Subject: RE: Planning Consultation on A/132/19/DOC

Engineers Comments Regarding Surface Water Drainage

Condition 4: Surface Water Drainage

TYPICAL HYDROBRAKE MANHOLE DETAIL
CHAMBER IS TO BE CONSTRUCTED TO FLOW CONTROL
MANUFACTURERS SPECIFIC REQUIREMENTS

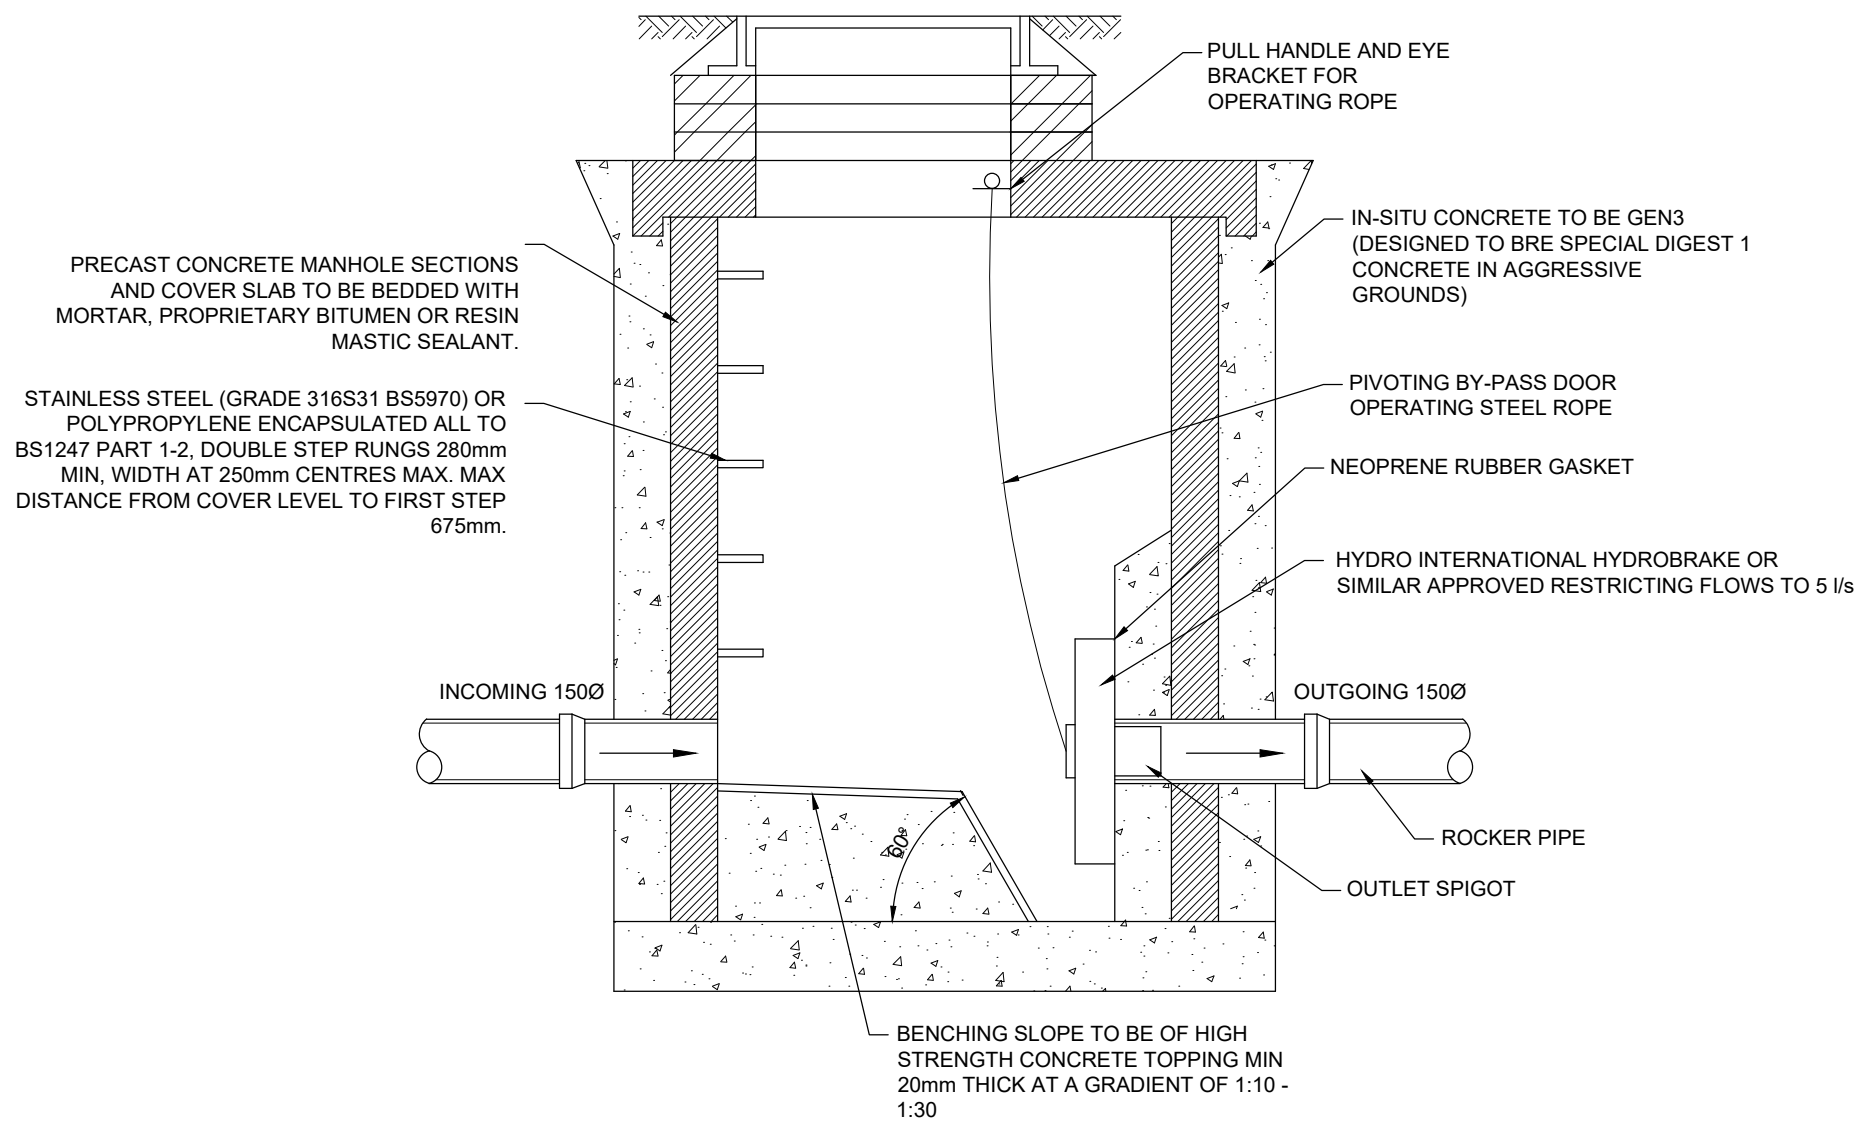
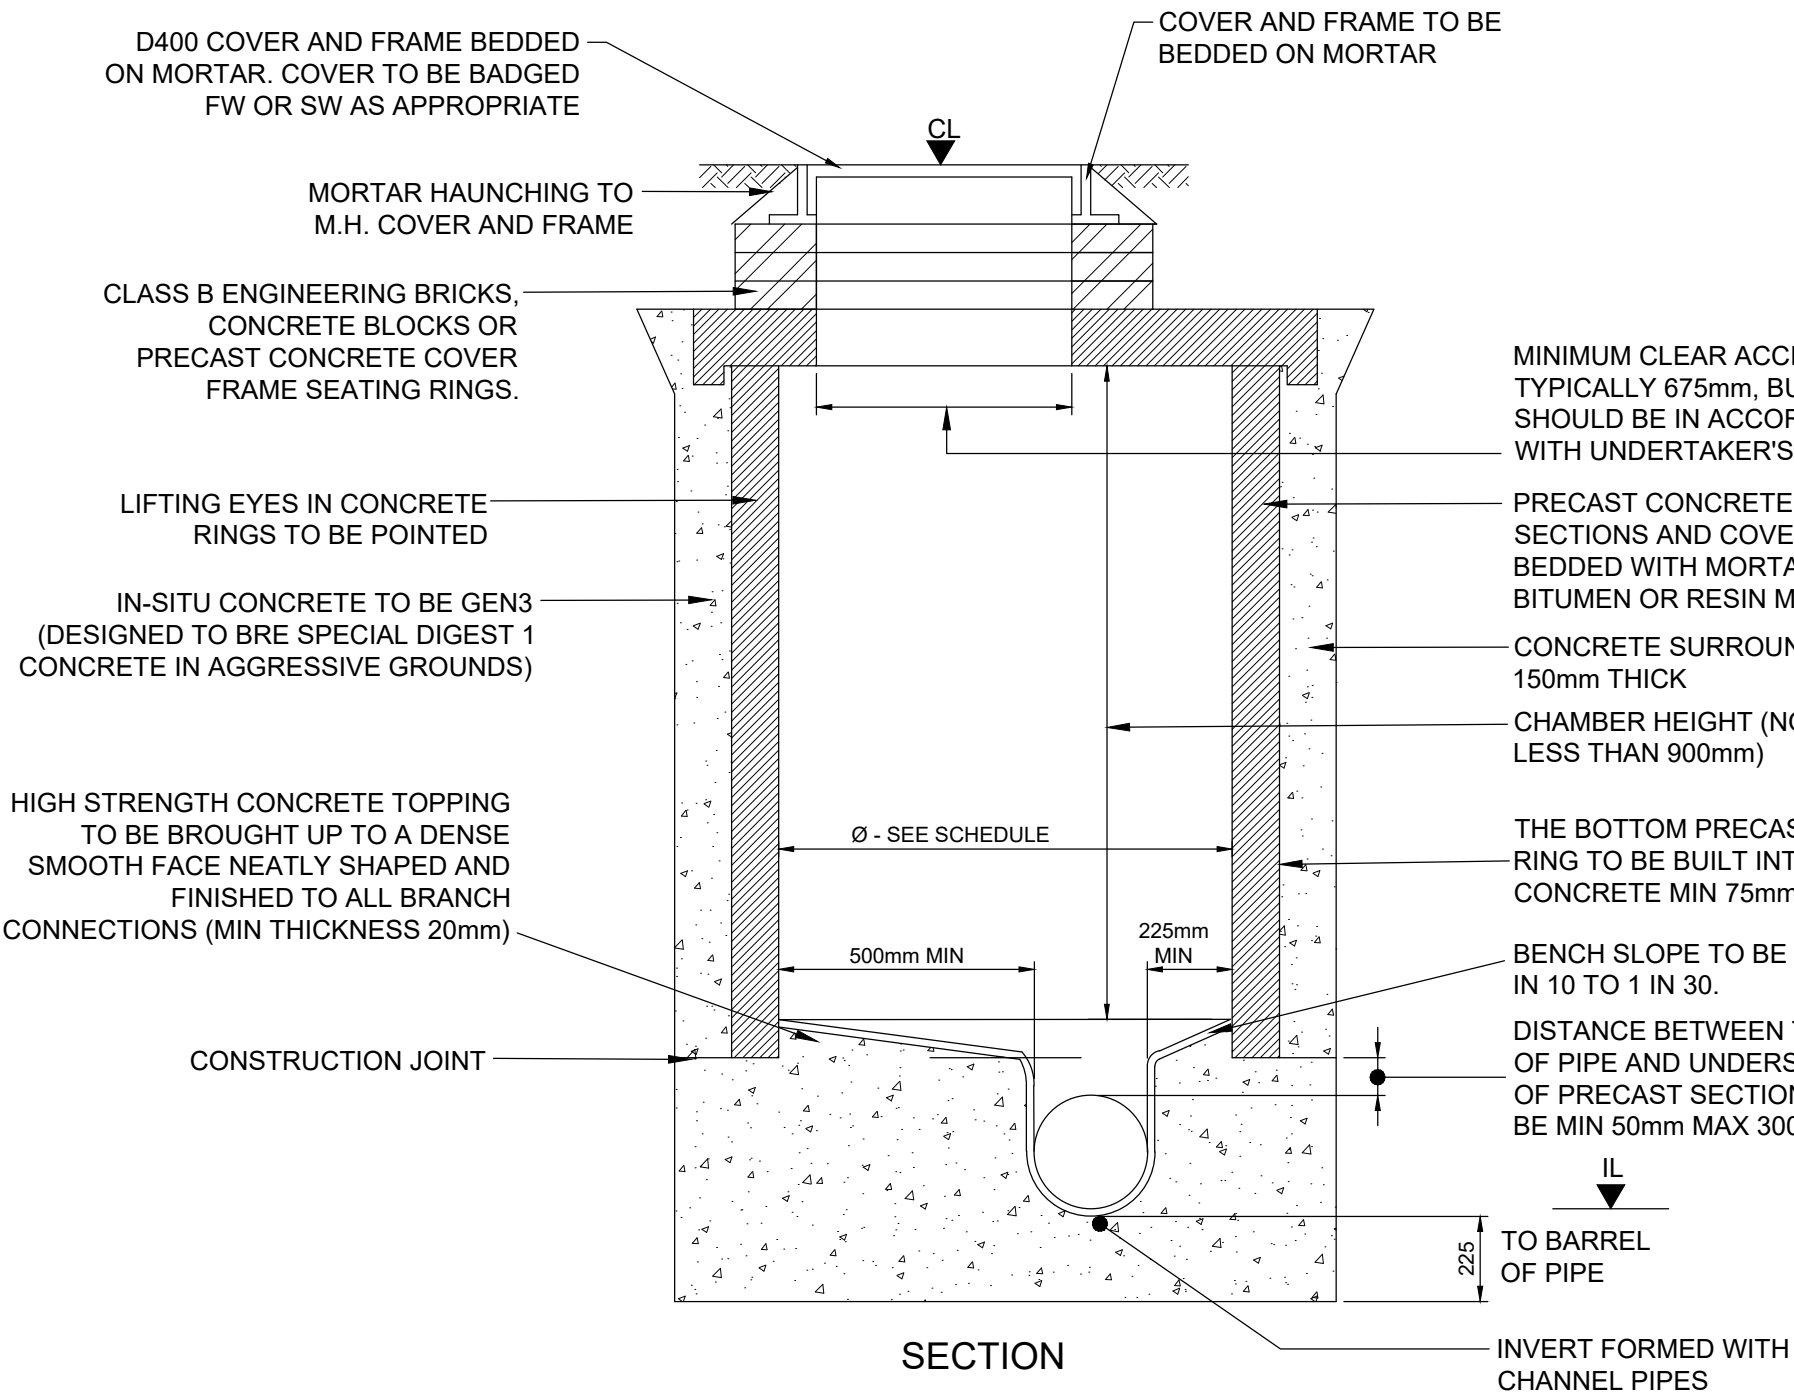
9. Pipe diameter and invert levels are required for S11 to tank -- Noted and added Fine
10. Hydrobrake manhole detail needs more detailing, i.e. Ring diameter, cover type, brickwork etc, similar to type B detail. Pipe diameters on the detail are incorrect -- Noted and adjusted Fine

**CONNECTION TO SAME
SIZE DIAMETER PIPE
(PLAN)
(1:10)**

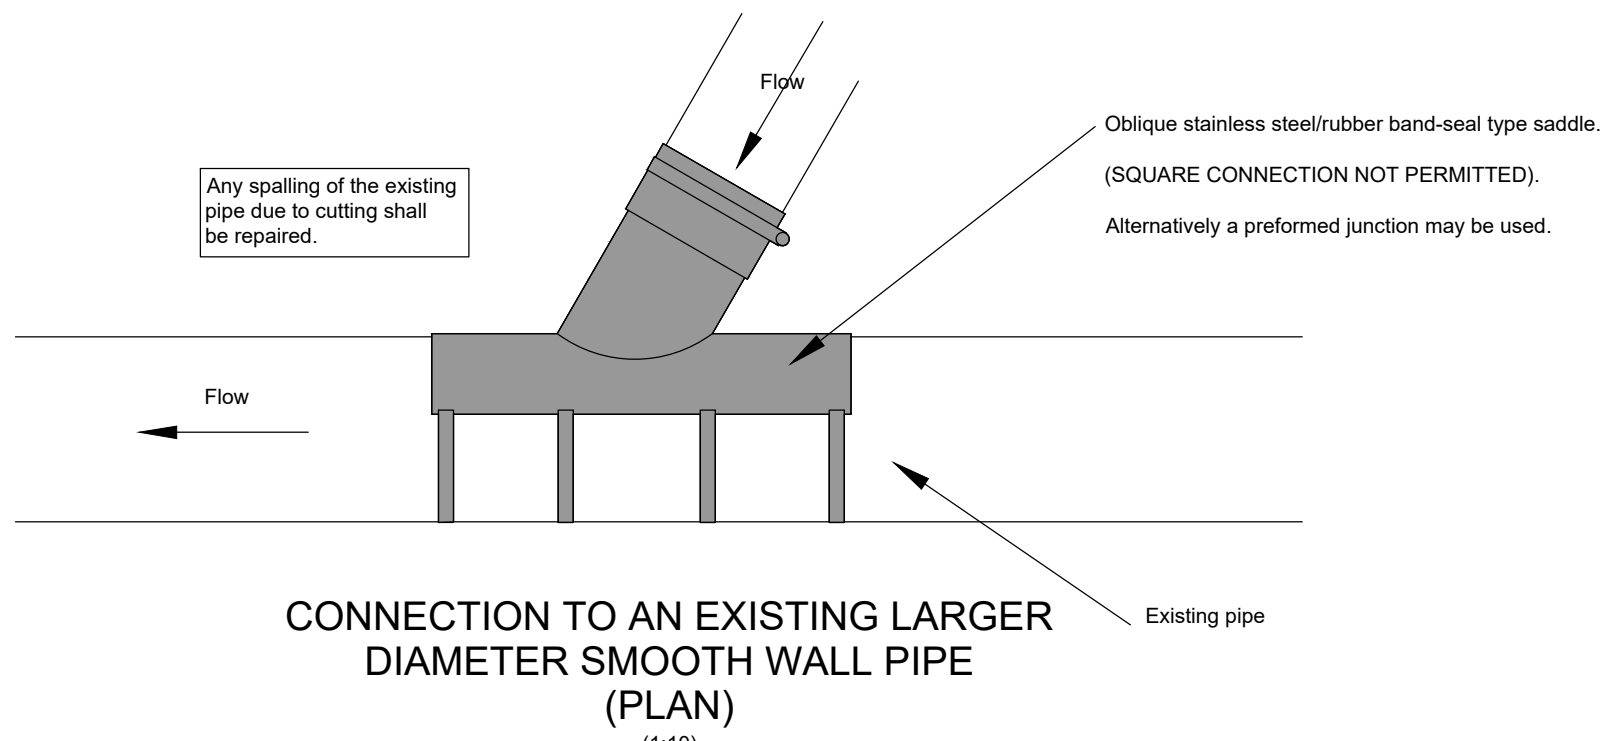
11. Note 15 on the plan – add D400 required in carriageways (access road) -- Noted and added Fine
12. Junction detail – Square is not permitted, the junction must be oblique and is applicable to pipes of equal diameter or not – Detail removed and note added in notes to reinforce this Please show an oblique connection detail in the drawings -- Detail now shown

DRAINAGE LEGEND (1:200)

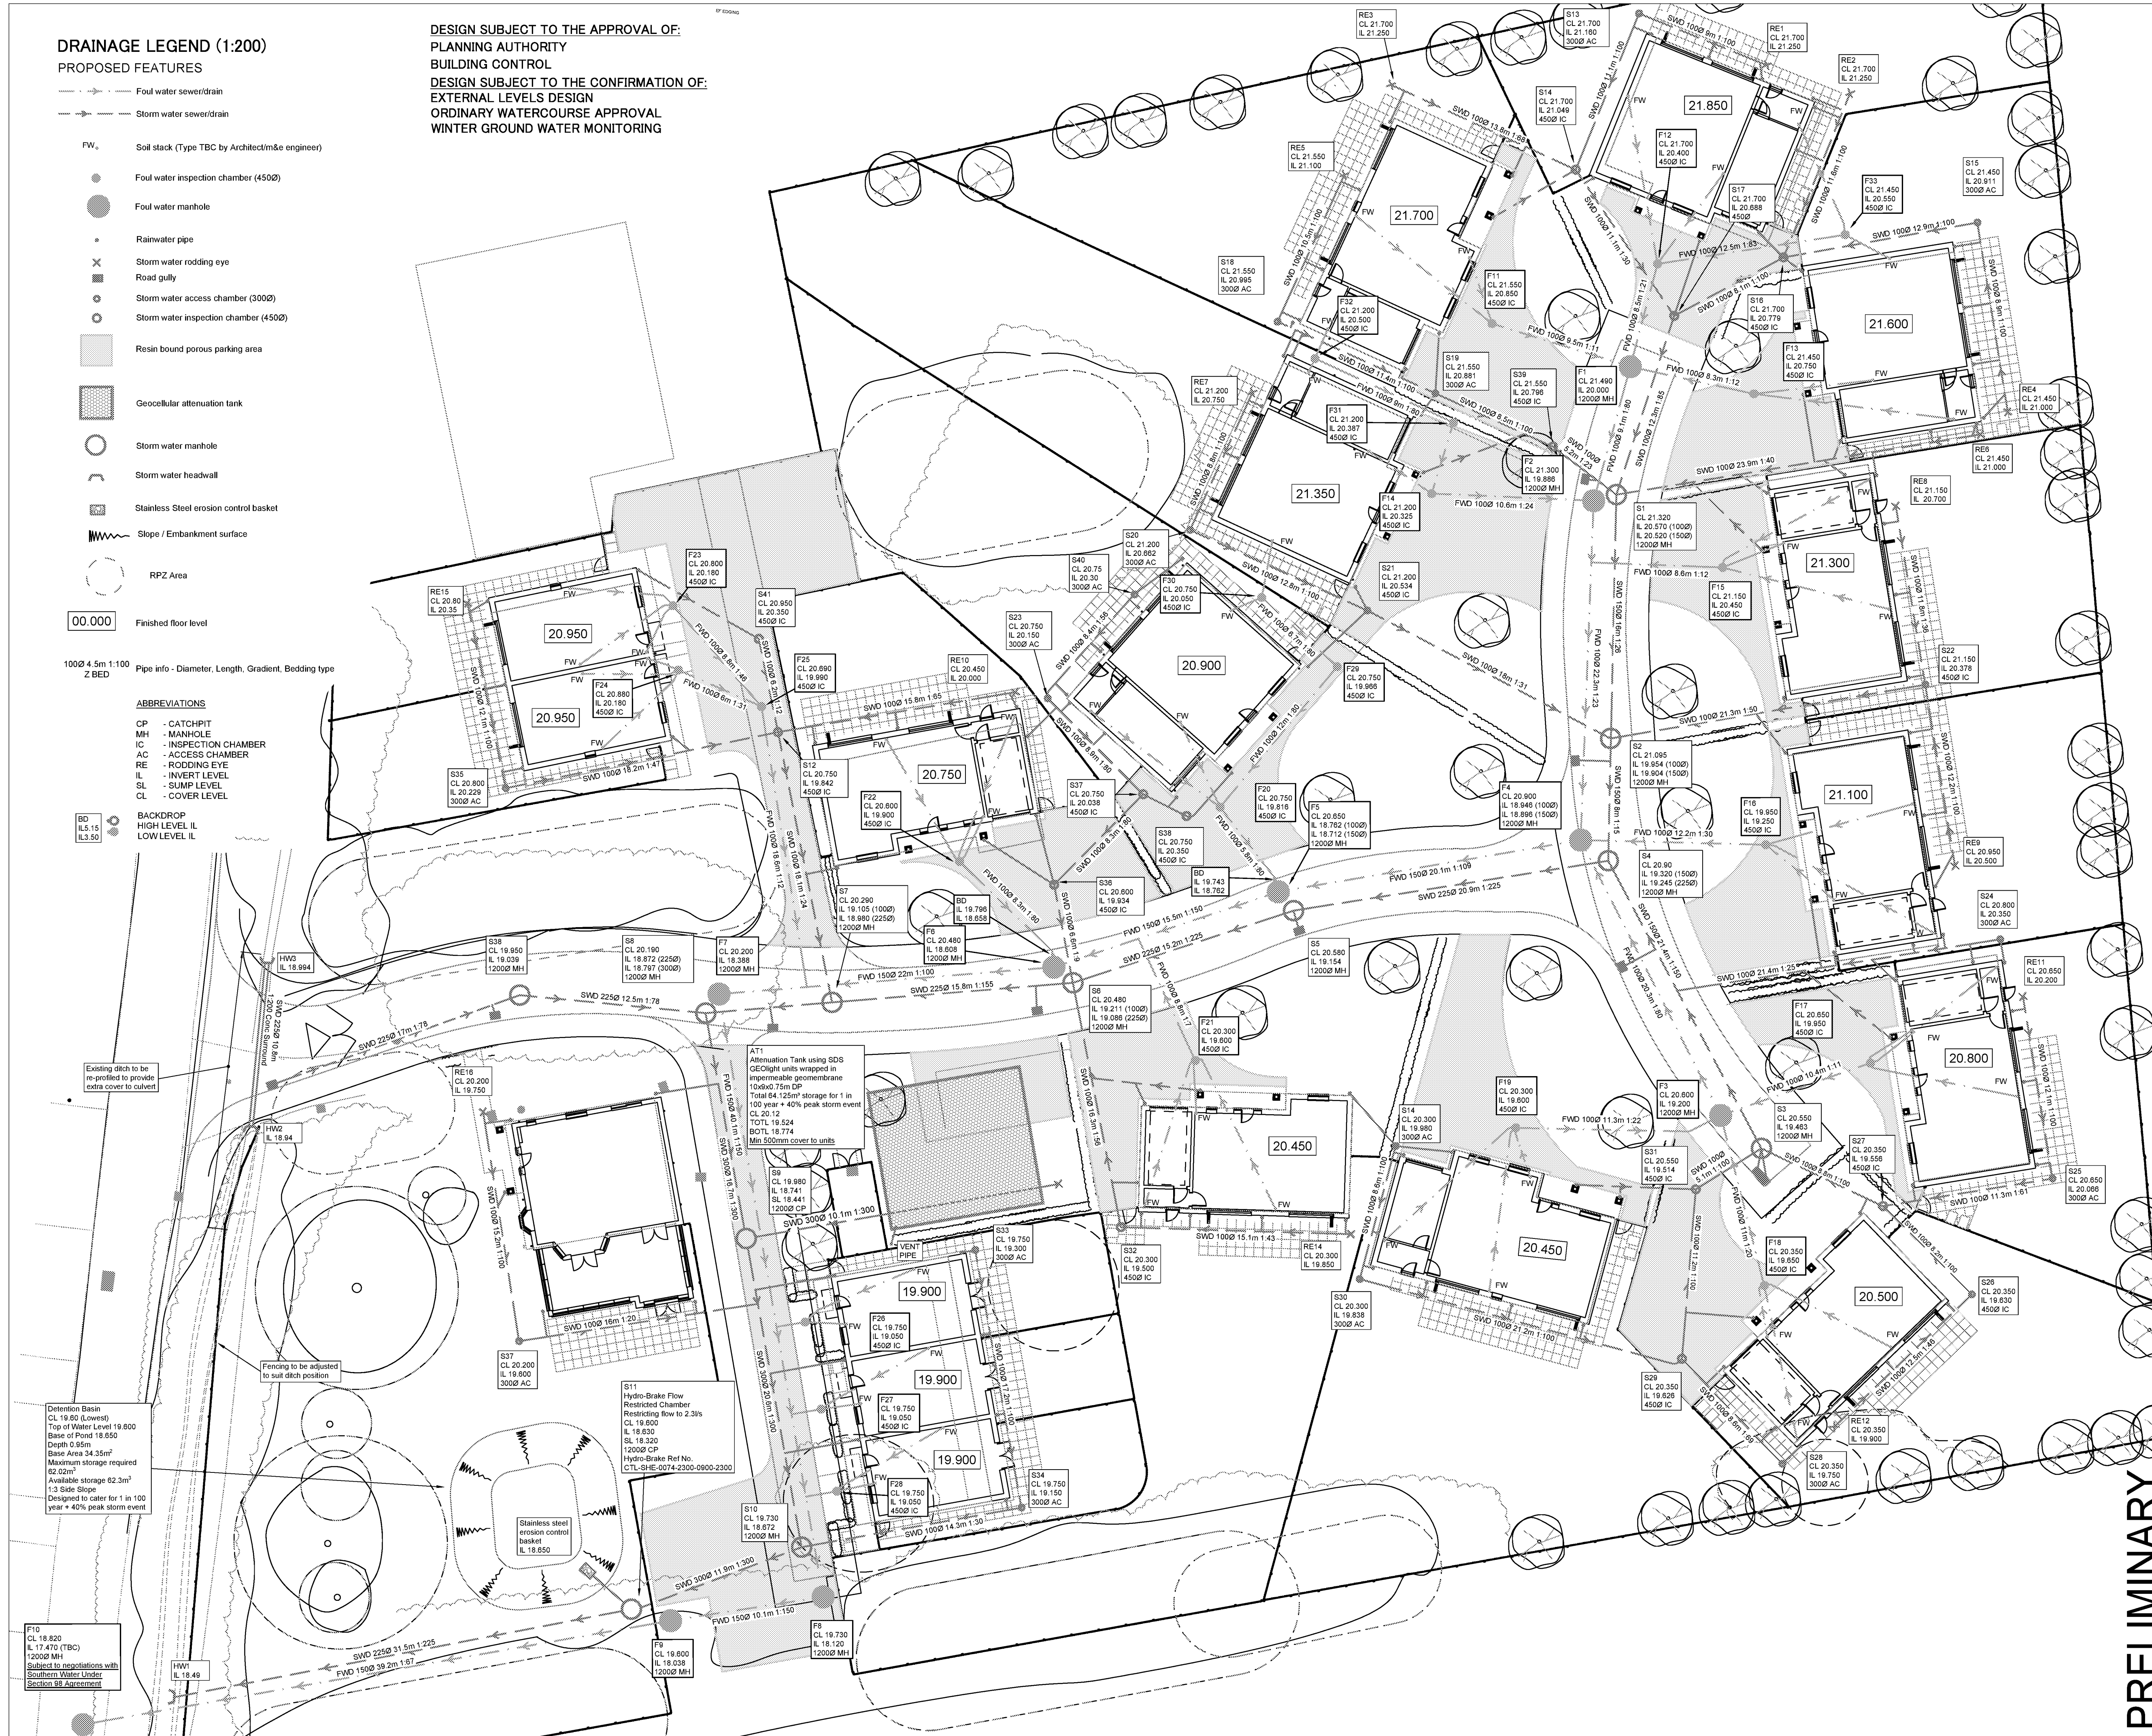
3. There should be a manhole/inspection chamber between S3 and S4 where surface water from two units join the network. -- Noted and added Fine
4. Pipe materials need to be covered in notes. -- Noted and added Fine

7. Need a sump manhole detail for S9 and S10. (S10 not currently shown as a catch pit manhole but it is recommended that this is changed as the Hydrobrake does not have a full catch pit only a small sump.) -- Noted and added Fine

13. Detail required for the concrete baffle just beyond S10 -- Noted and added OK, but please specify the height of the baffle on the drawing -- Height of 200mm added

14. Permeable pavements – specify finished levels/base (formation) levels on plan -- Adding these levels congests the drawing so we have chosen not to add it to ensure clarity. The contractor can calculate formation levels based off of the finished levels and construction detail which confirms depth of construction Finished levels are needed to show that the fin drains are in the correct locations -- Finished levels drawing attached to confirm.

15. Detail required for proposed land drains – some plots don't have one, amend to help with run off from patios. -- Detail added. We had chosen land drains for just the plots that cut into existing levels. We have however now shown for each plot. Fine
